# CITY OF ALBUQUERQUE

January 23, 2018

**Re: Murphy Express -1358 Wyoming Blvd NE  
Erosion Sediment Control Plan  
Engineer's Stamp Date 11-15-17 (J20E037)**

SHEET NO. **C-4.1**
 JOHN H. NOURDAD
 NEW MEXICO
 PROFESSIONAL ENGINEER
 11/15/17

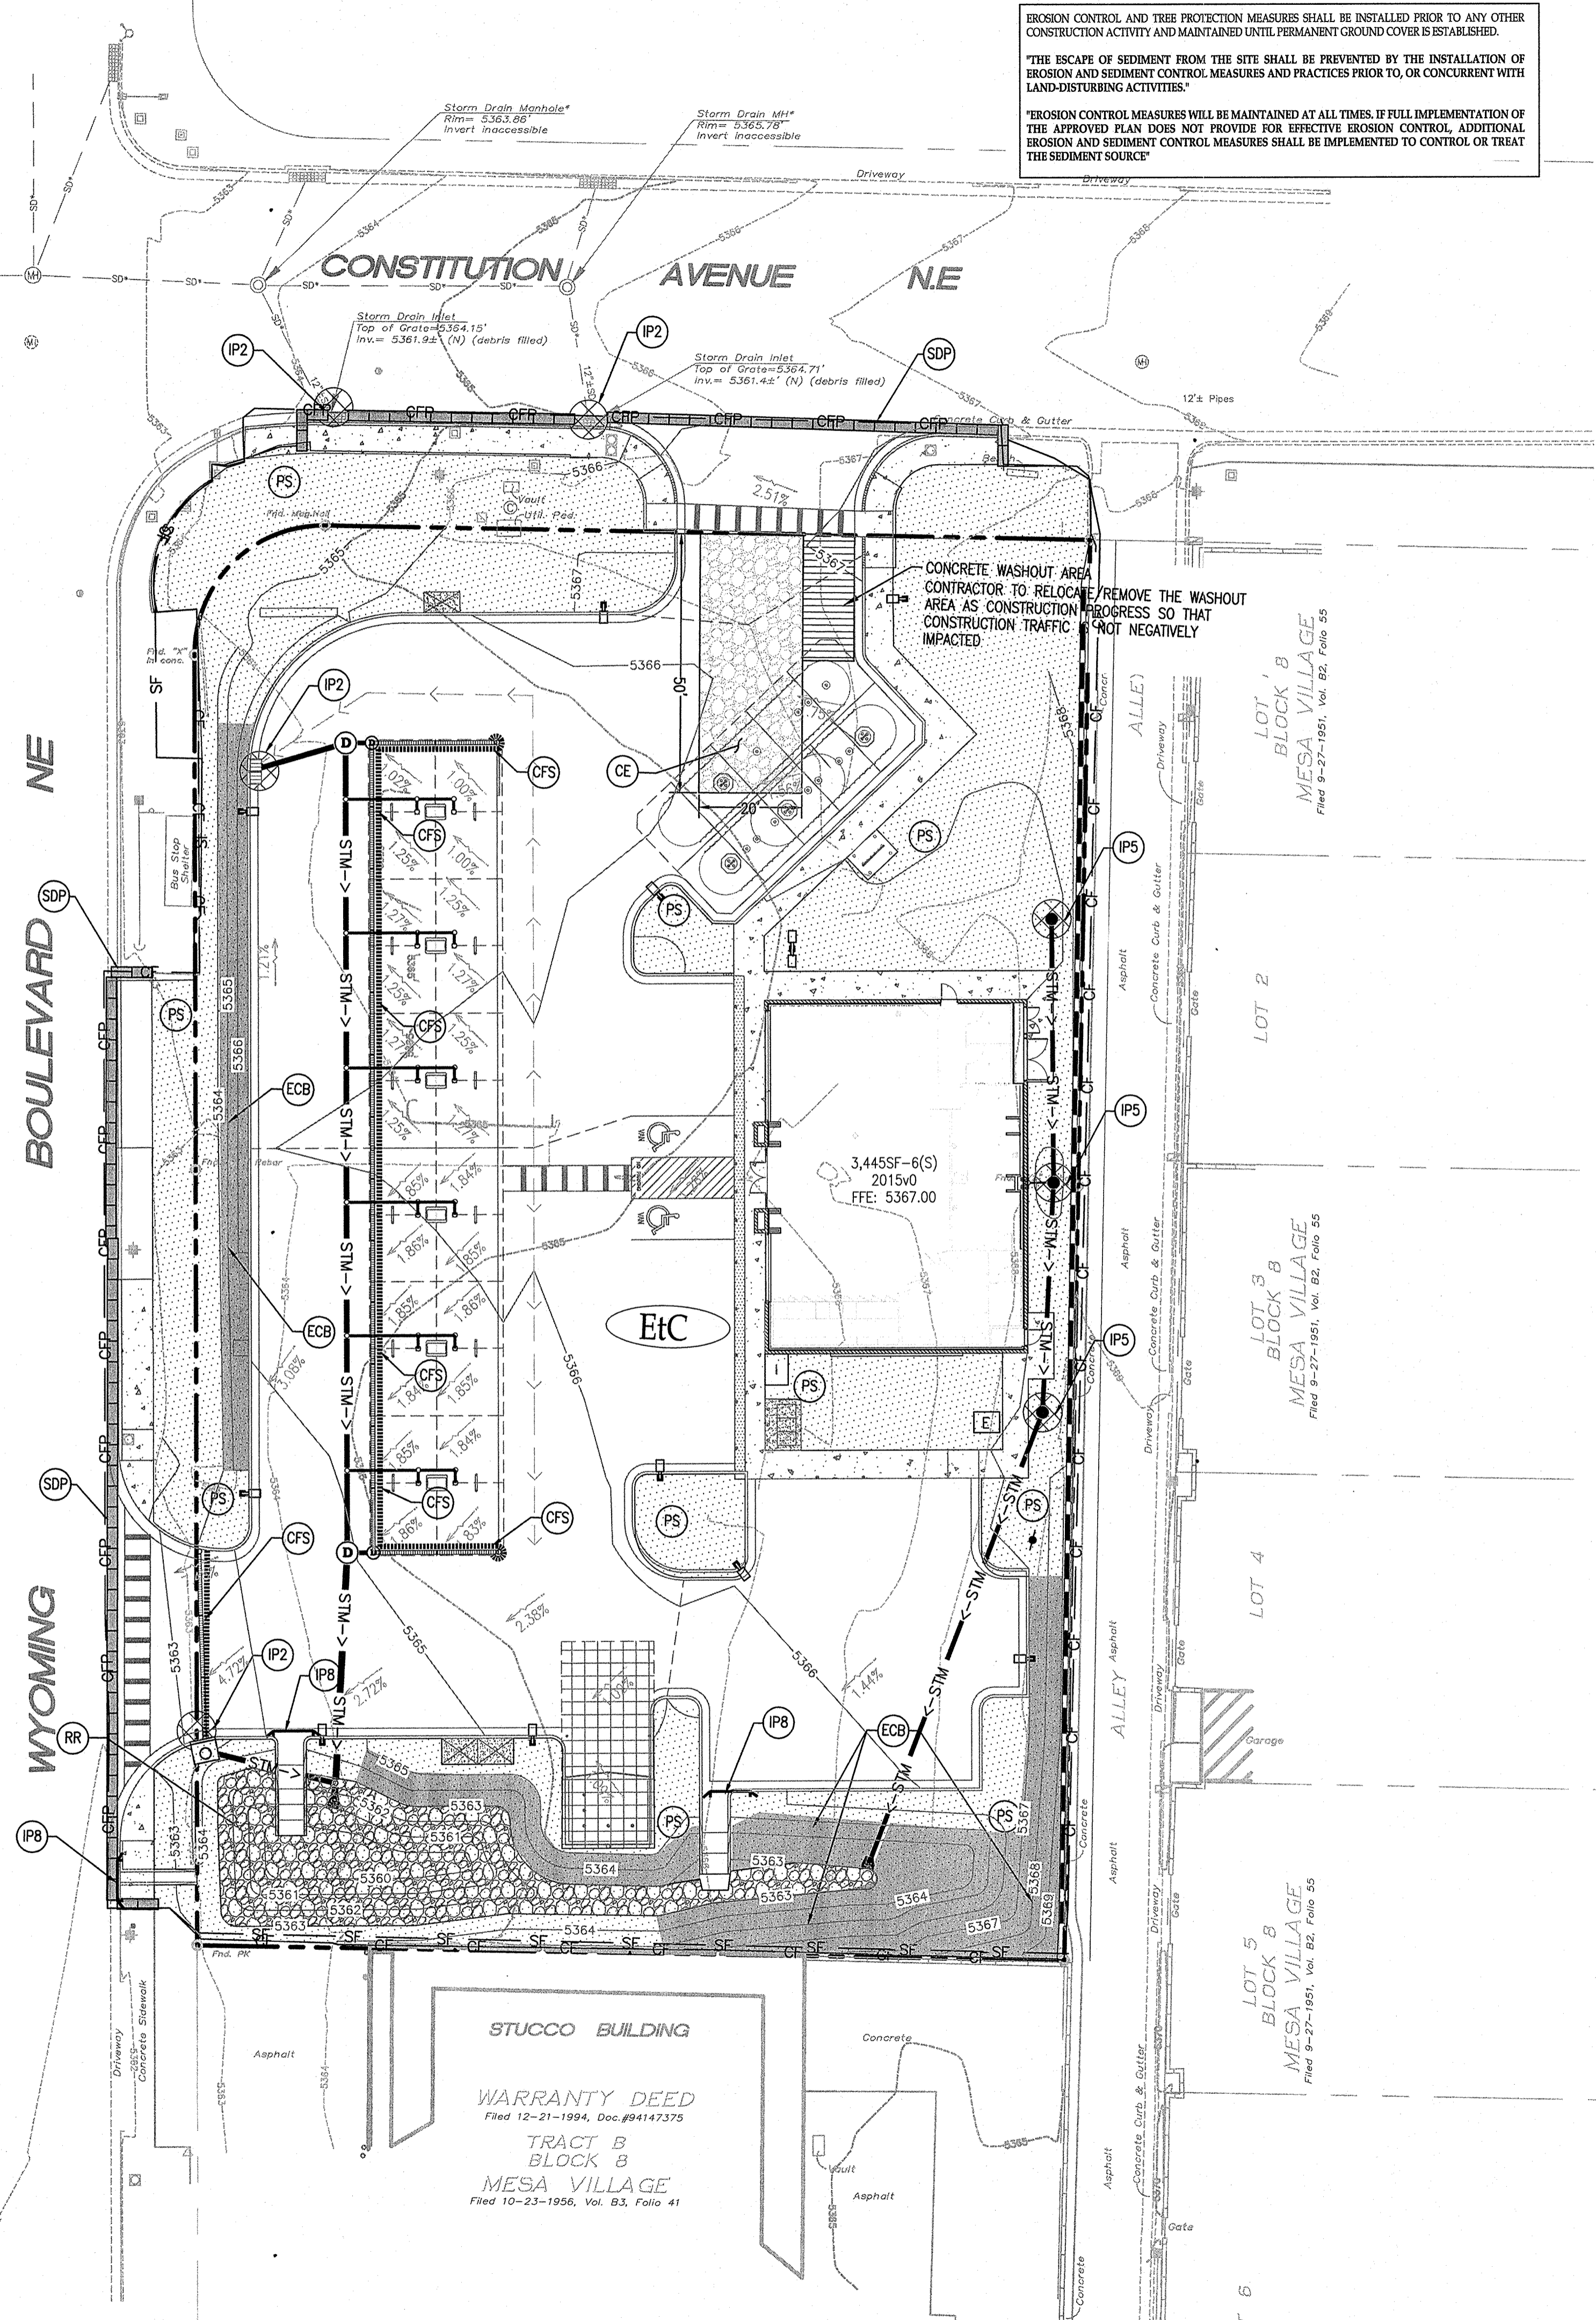
1. Remove the silt fence dike on pavement (SDP) BMP shown in the gutter pan and replace with silt fence/filter sock/sediment BMP at the boundary between disturbed and undisturbed, most likely inside the sidewalk.
